Planning Application Ref: A/150/17/T

Location: St Margarets Court, Arundel Road, Angmering

Description of works: Fell 1 No Lawson Cypress and carry out crown reduction to all others on site.

**St. Margaret's Court
Appendix 5 - tree survey plan**

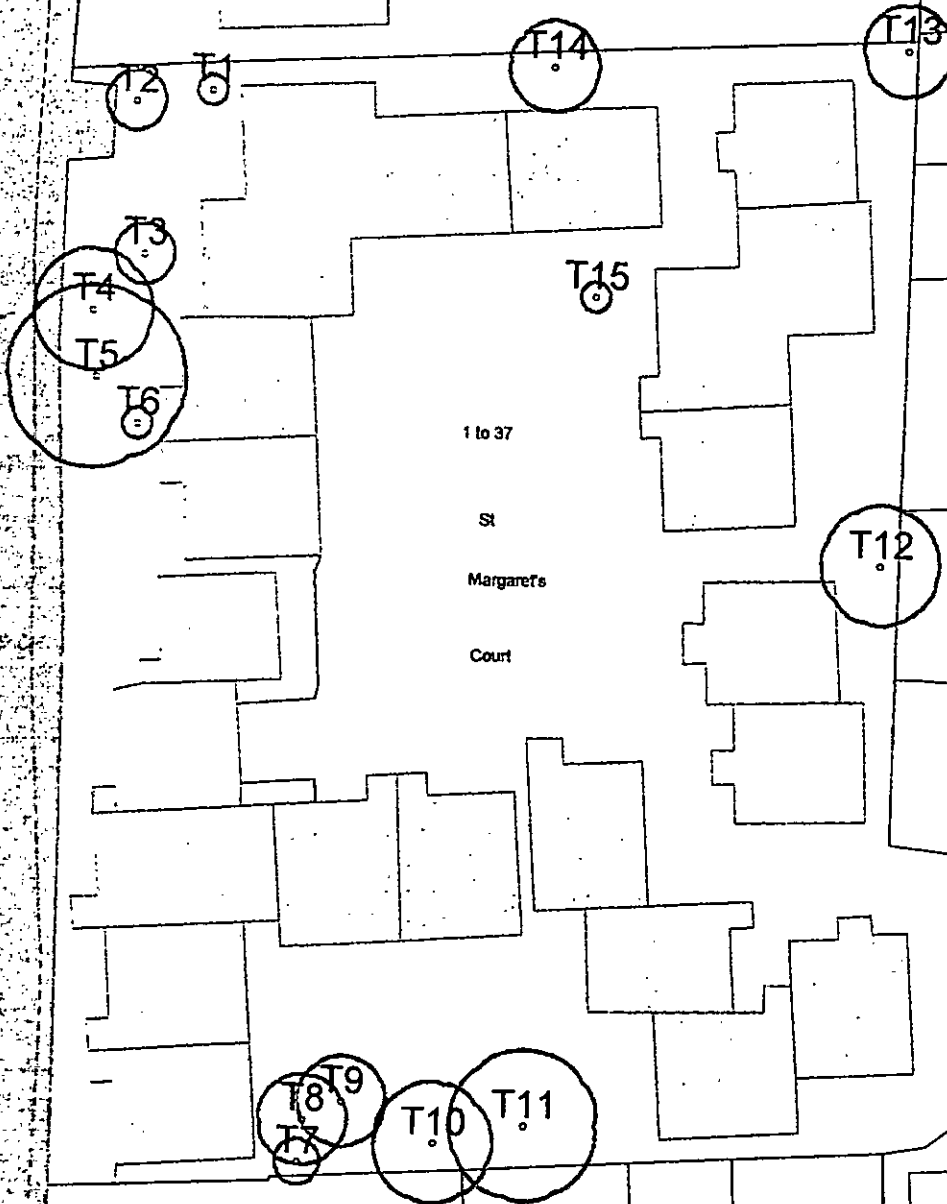
- The application states 20% and 30% reductions [which equate to 2m to 3m and then it states all trees to be reduced by 4m which is confusing and contradictory.
- The **Blue Cedar T4** does not require any works being undertaken to it as this would undermine its amenity value in the landscape.
- I can see that the **Lawson Cypress T3** is a very poor tree and hinders the growth of others so am happy to see it removed.

- The work proposed is standard maintenance and I have no issues with this being undertaken but I do object to the excessive amount of reduction which has been requested.

- I recommend **APPROVAL** for the felling of Lawson Cypress T3 [no replacement tree will be required on this occasion].
- I recommend **REFUSAL** for all other the works as listed in the application.

T1 Box Elder – reduce crown by 1.5m to 2m maximum.

T2 Lawsons Cypress - reduce crown by 1.5m to 2m maximum.

T3 Lawsons Cypress – fell to ground level

T4 Blue Cedar – no works advised at this time

T6 Mountain Ash - reduce crown by 1m maximum.

T7 Judas Tree - no works advised at this time

T8 Silver Birch - reduce crown by 1.5m to 2m maximum.

T9 Silver Birch - reduce crown by 1.5m to 2m maximum.

T10 Sycamore - reduce crown by 2.5m to 3m maximum.

T11 Sycamore - reduce crown by 2.5m to 3m maximum.

T12 Box Elder – reduce crown by 1.5m to 2m maximum.

T13 Mountain Ash - reduce crown by 1m maximum.

T14 Hawthorn - reduce crown by 1.5m to 2m maximum.

T15 Cherry - reduce crown by 1.5m to 2m maximum.
